Your Ref: OWPC21626
Our Ref: K/40/18/PL 14-11-2018
Please ask for:
Mrs A Gardner

Demolition of existing dwelling & erection of 1 No. dwelling, associated landscaping & parking (resubmission following K/11/16/PL).

Spring Tide Gorse Avenue East Preston

Proposed West Elevation 1 / 100

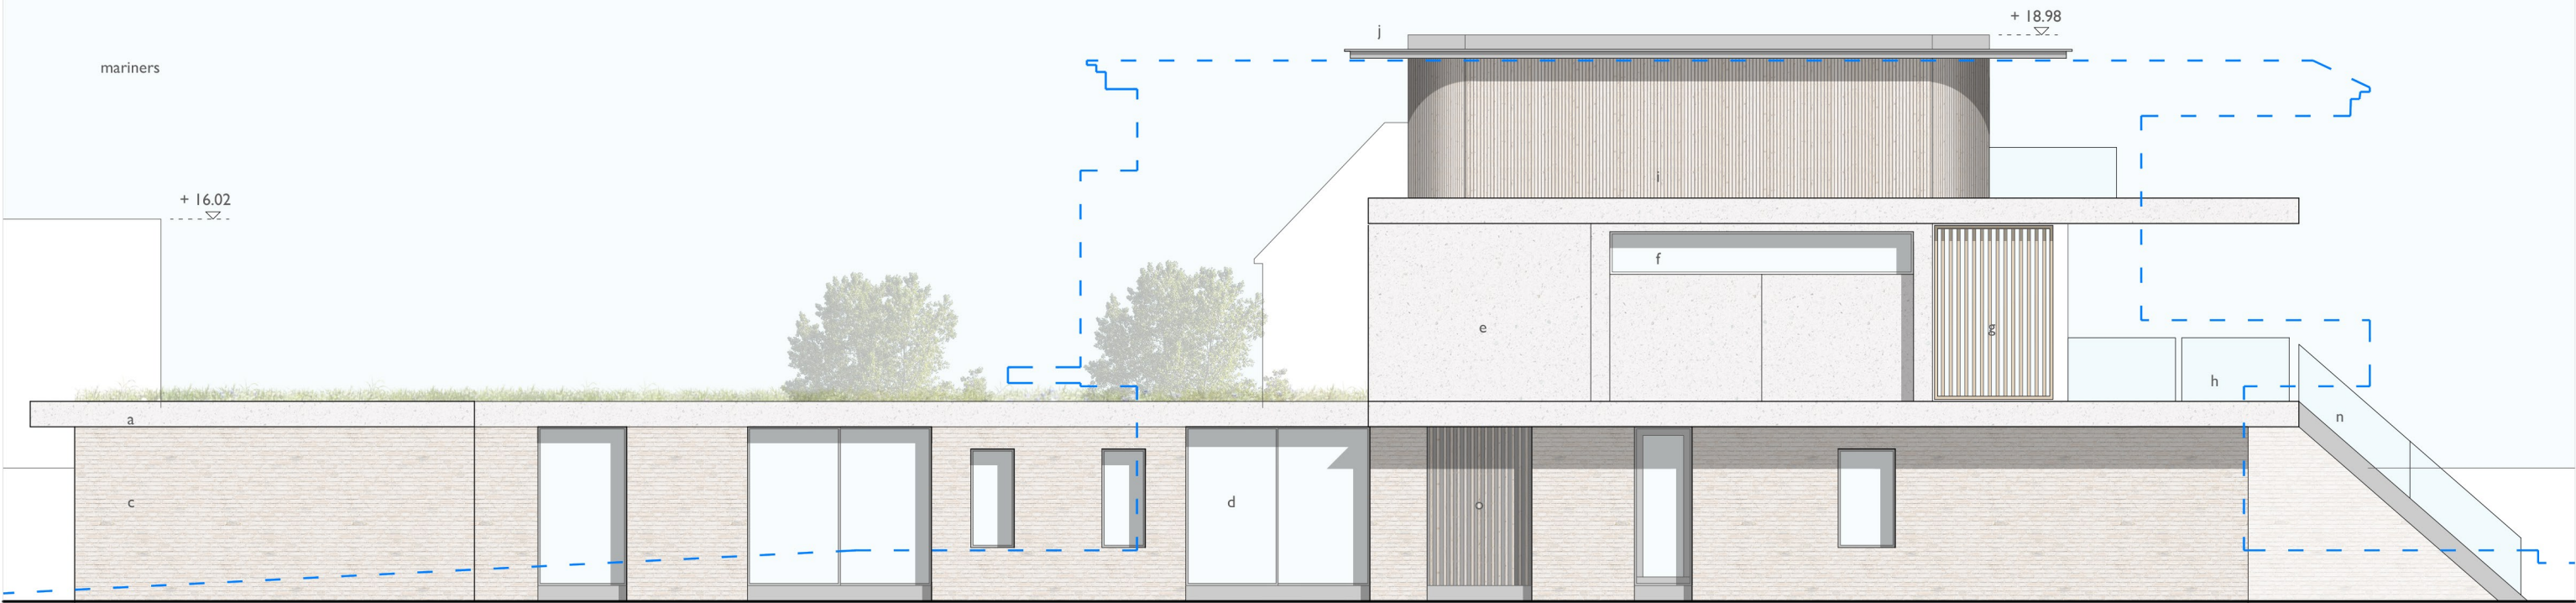
- 3.
The excessive use of balconies overlooks all neighbours to the west, north and east.*
- 4.
The proposed building line runs along, or very close to, the fence bordering the Twitten. To have such a high construction close to the Twitten would compromise the rural setting and atmosphere that is enjoyed by Kingston Gorse residents.*

Proposed North Elevation 1 / 100

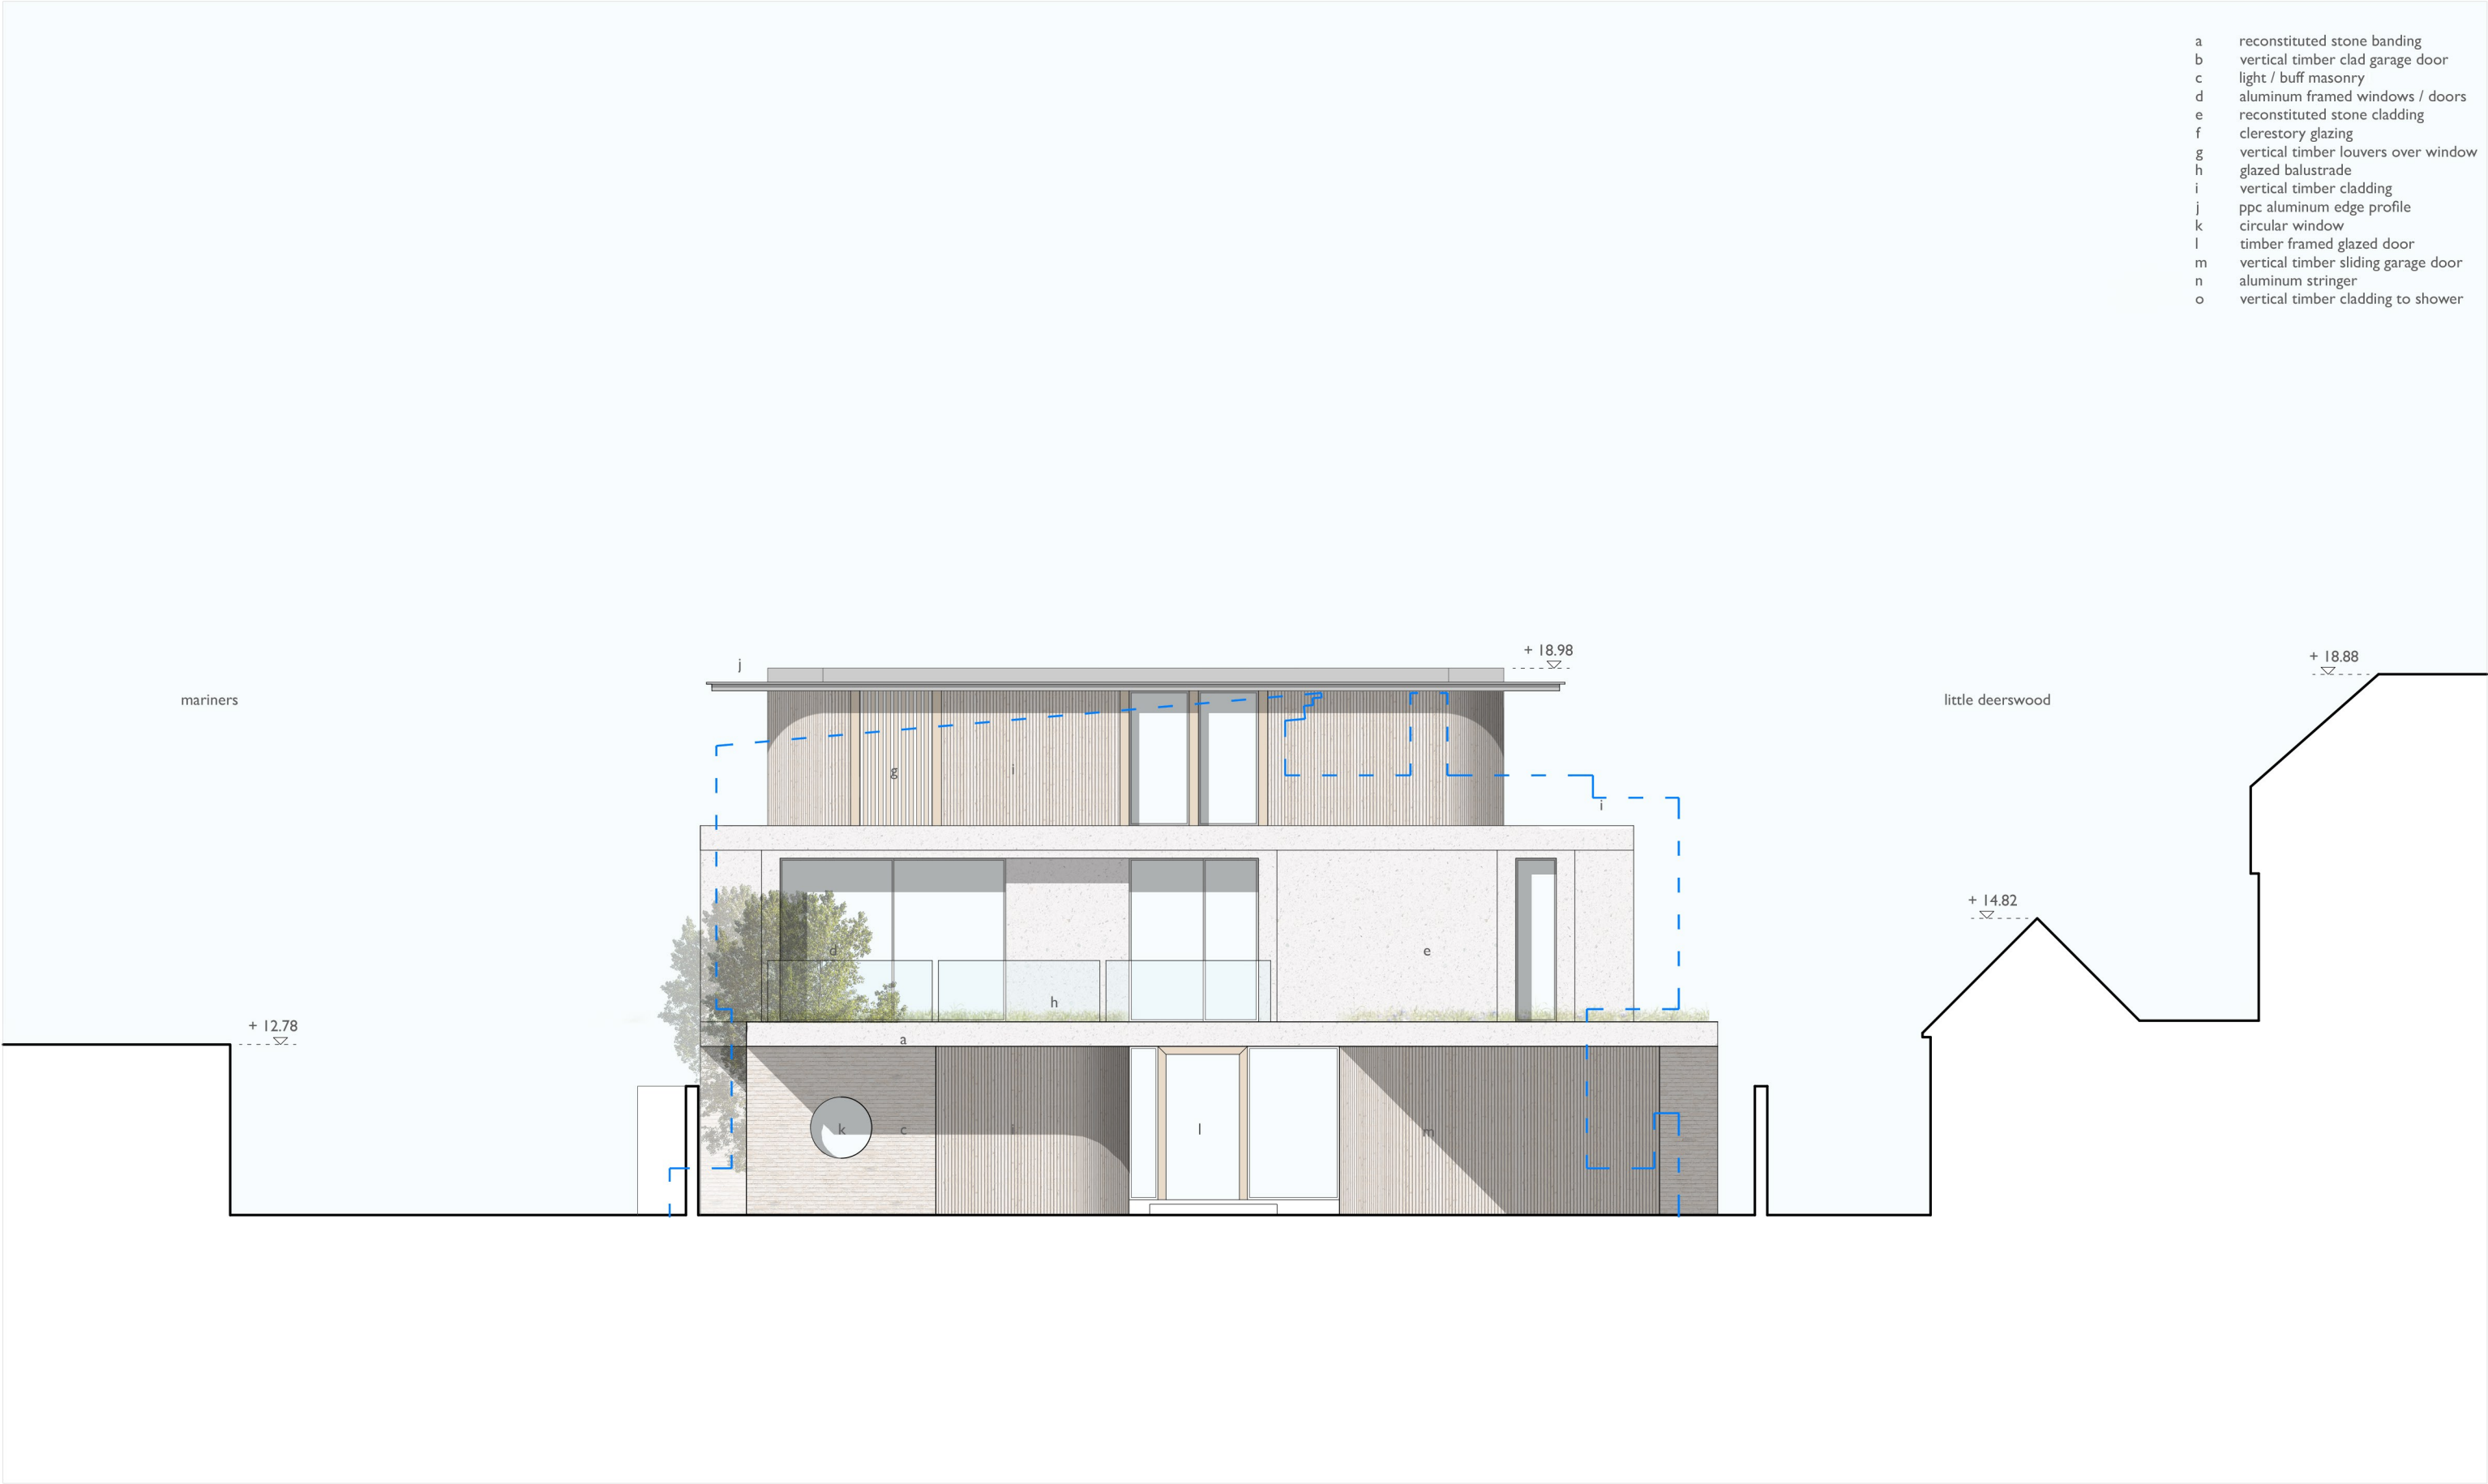
- 1.
The proposed dwelling is visually out of scale to the existing property, an overdevelopment of the site and very overbearing to Mariners and all neighbours to the West, North and East.*

- 2.
The three storeys which are proposed makes the new Springtide much higher than the surrounding homes. It is detrimental and severely out of character visually to Gorse Avenue and Kingston Gorse as a whole. The charm of which is its traditional properties.*
